Application Reference: 2026/0434

Site Address: 17 Barnwell Crescent, Wombwell, Barnsley, S73 8EB

Introduction: This application seeks full planning permission for a Single storey side extension to dwelling

RE	DAT	B	AMENDMEN
<b>PLANNING</b>			
DAT	SCALE @	DRAWN	
E09/03/26	As indicated	BY: AN	
DWG Planning Elevations			
DRWG	RE		
83/002	V:

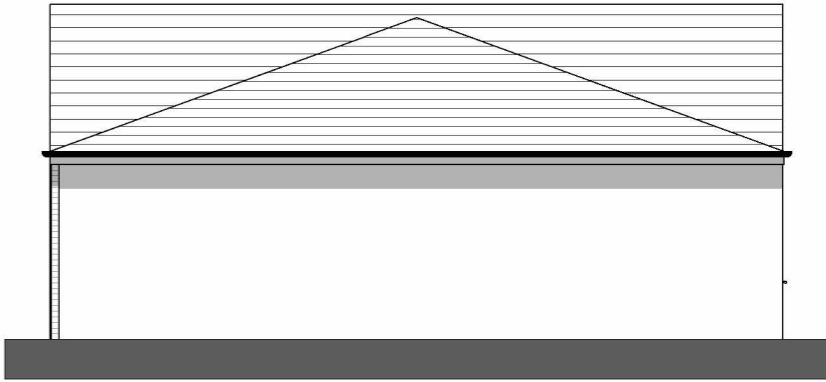
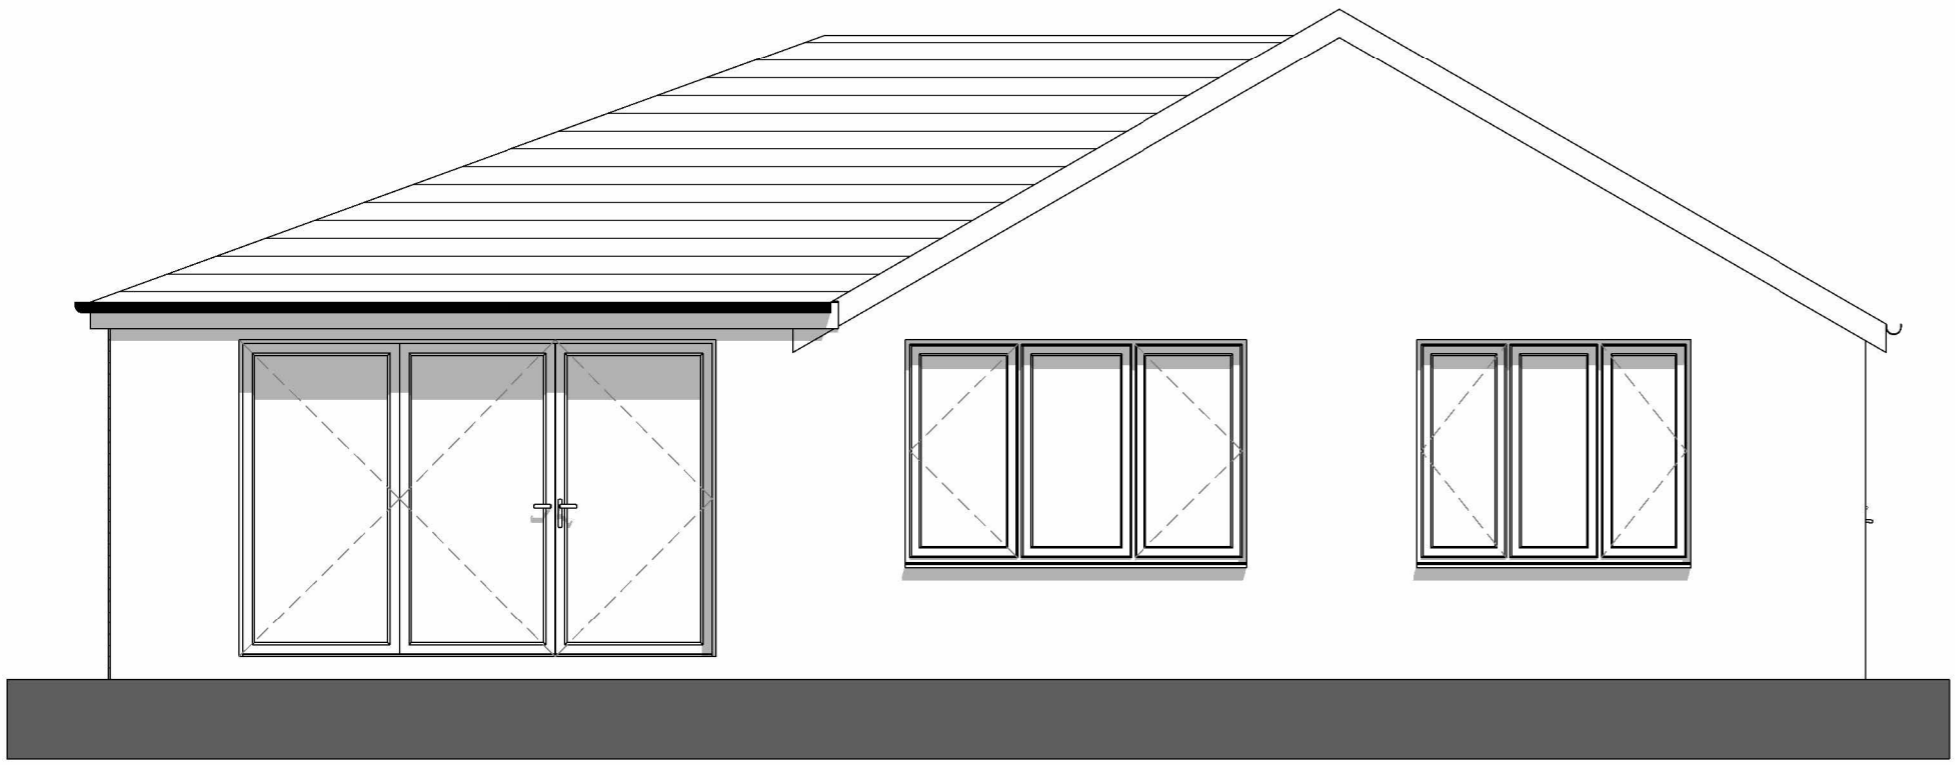
The existing bungalow has an approximate width of 7.10m. The proposed ground floor extension would extend this width by approximately 4.5m, to 11.6m. As the proposed extension would be less than two thirds (4.73m) the width of the original dwelling, this would be considered acceptable in regard to the SPD House Extensions and Other Domestic Extensions. There is no set back from the front elevation of the original dwelling, which is usually a SPD requirement, but this is not uncommon for a bungalow, especially a detached one. Further mitigation for the lack of set back arises through the significant setback of the actual dwelling from its neighbours, and its principle entranceway located on the side rather than front elevation.

There is a small step down of the proposed roof of the extension, which with its complementary design adds to the overall positive re-design of the bungalow. Accompanying the extension is a refurbishment of the existing elevations of the dwelling, which instead of brick and partial rendered or painted sections would be, rendered in white. Further improvement on the front elevation occurs from the replacement out of character large, patio door style windows with two narrower long format windows separated by a brick accent column.

The proposed front elevation of the extension would be constructed of brick to retain some of the original character of the dwelling, but the remaining side and rear elevations would be fully rendered. Even with render, or painted features of similar appearance to render featuring across the original dwelling, and prominently within other dwellings across the street scene, full rendering of a dwelling is often restricted. However, on this occasion with the extension including a prominent brick façade, the unique setback position of the dwelling, providing an almost secluded location, and as noted the render within the street scene, it would only have a modest rather than significant impact on the character of the dwelling, and a limited impact on the street scene.
